From: Giles Dixon [REDACTED]
Sent: 17 August 2017 15:57
To: Anita Gardner
Subject: Re: AB/103/17/PL Former reception building.

> Subject: AB/103/17/PL Former reception building.

client:
Clarendon Properties Ltd
drawing title:
PLOTS 3&4 – Roof Plan

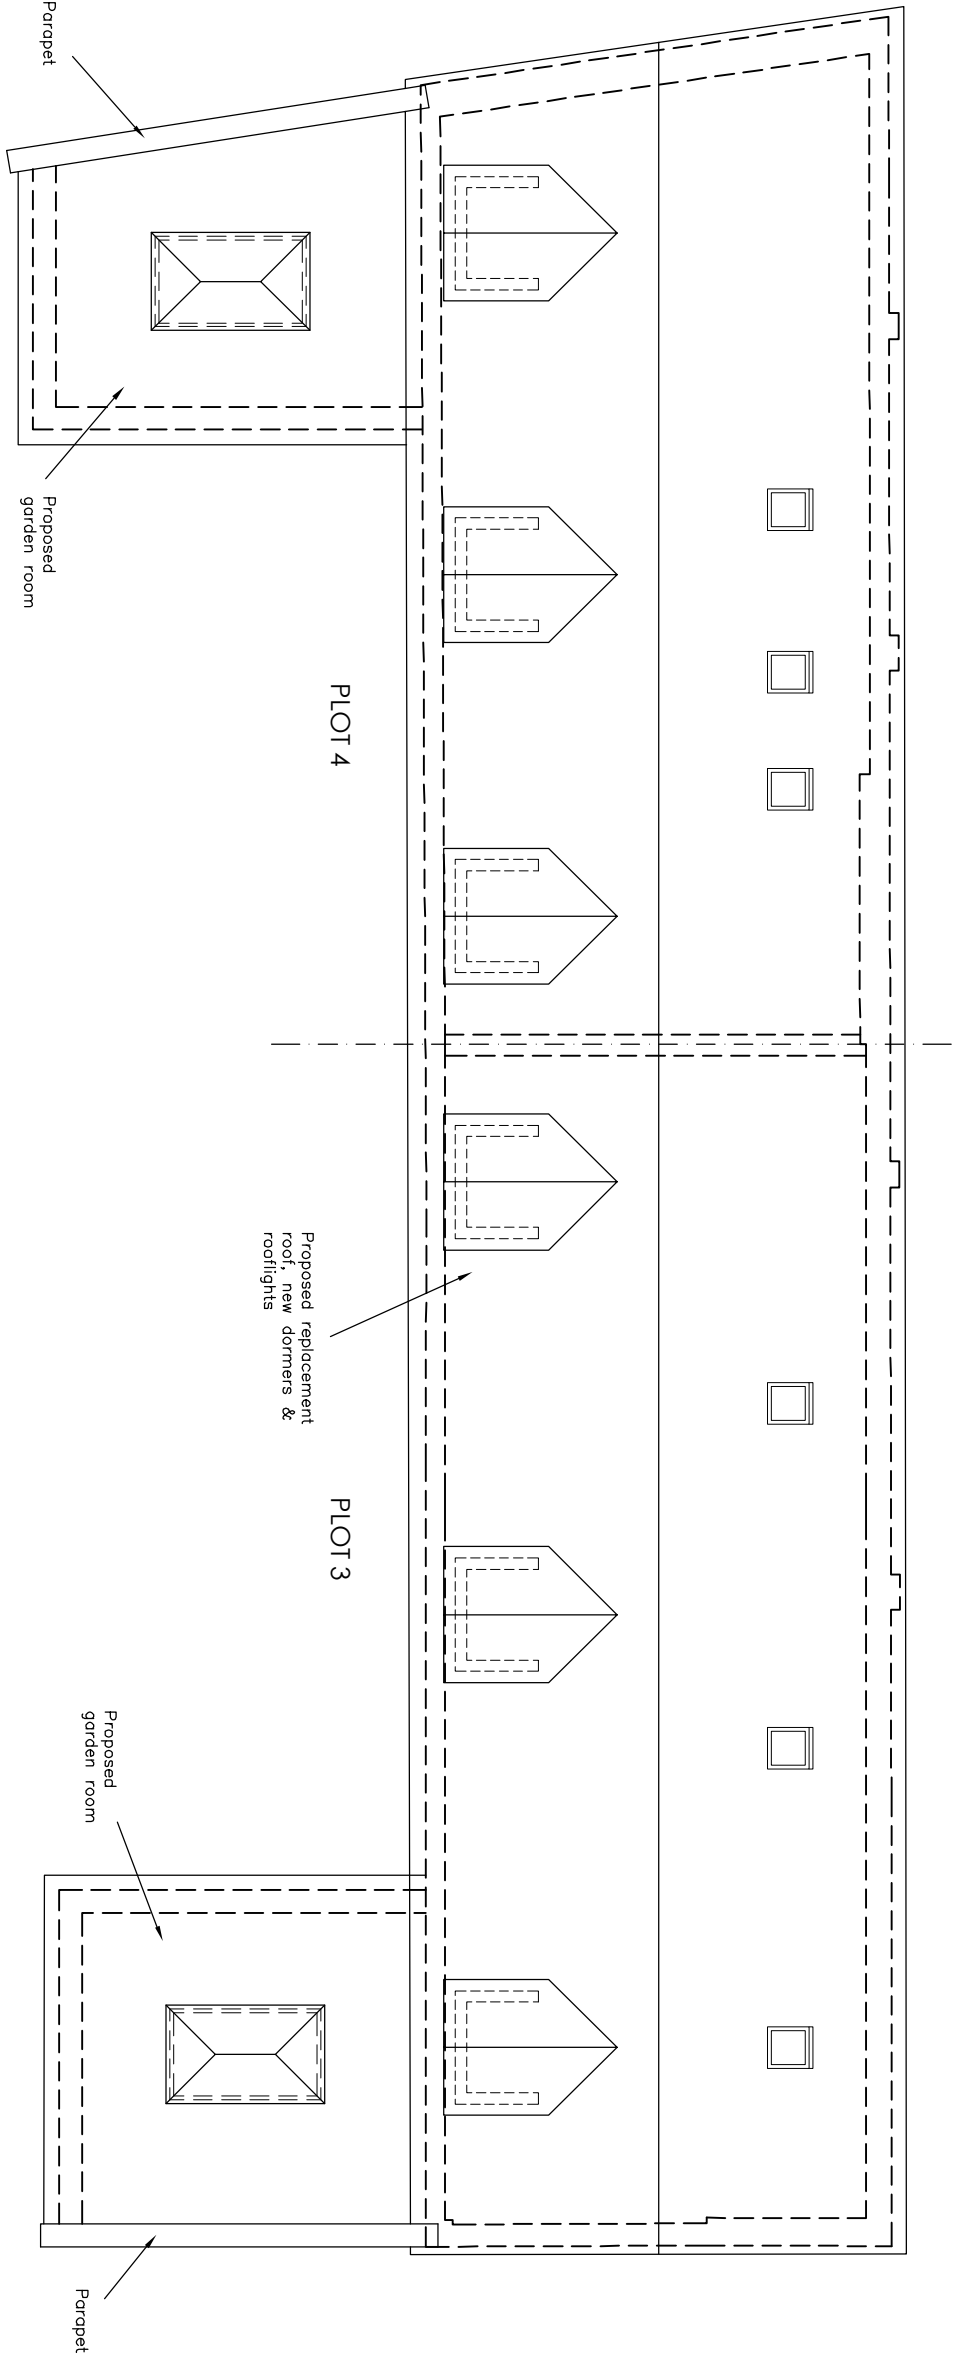
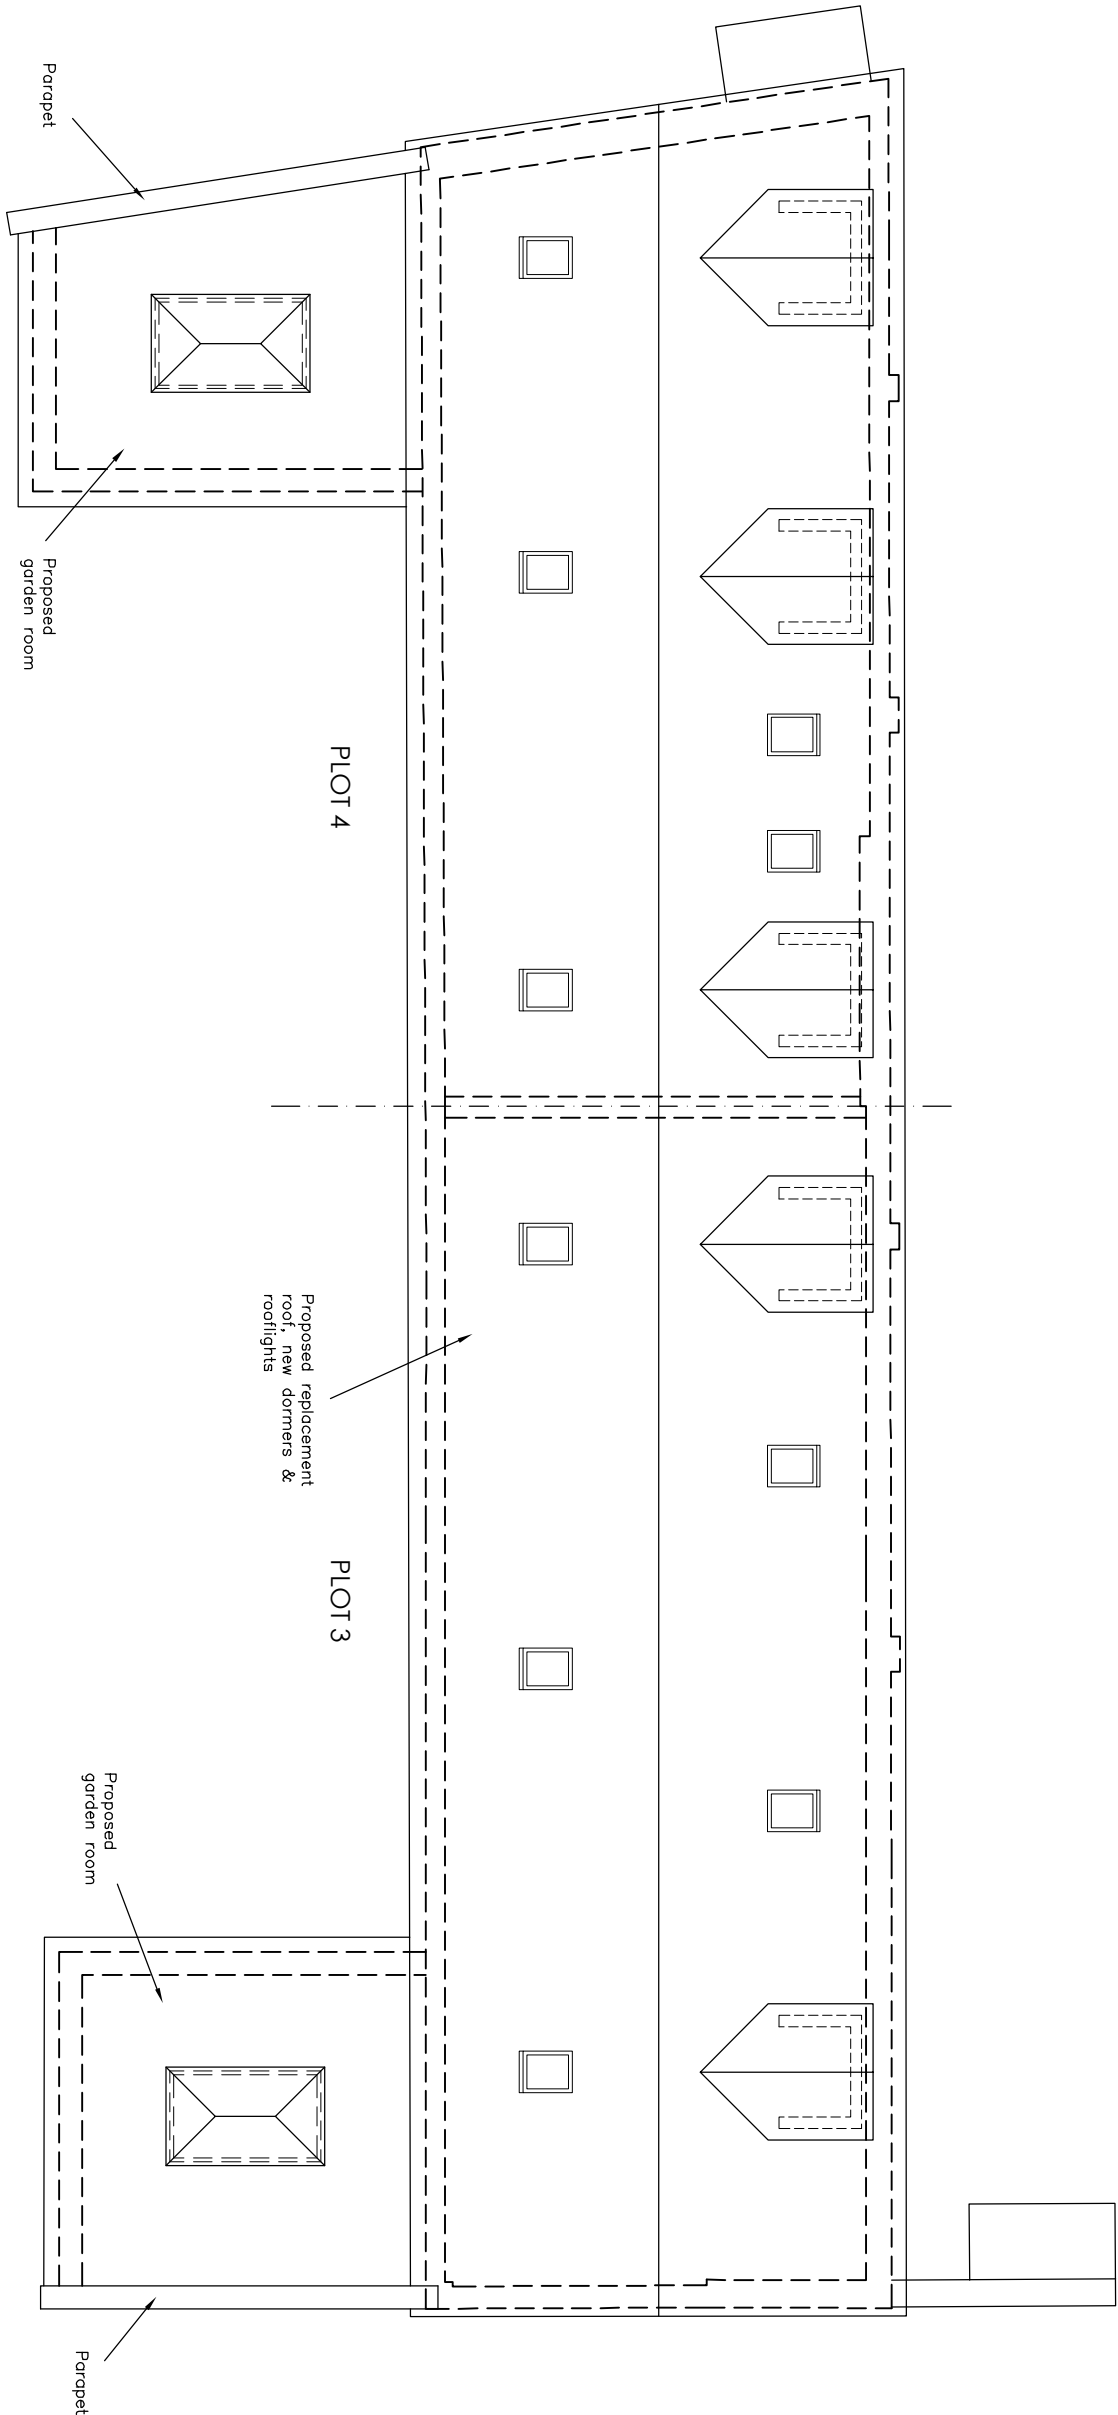
> We have been in conversation with the neighbouring homeowner to this property and they have voiced their concerns over the dormer windows to the rear of the property, potentially causing an overlooking problem.

> Therefore, please find attached amended plans showing the dormer windows relocated to the front of the building
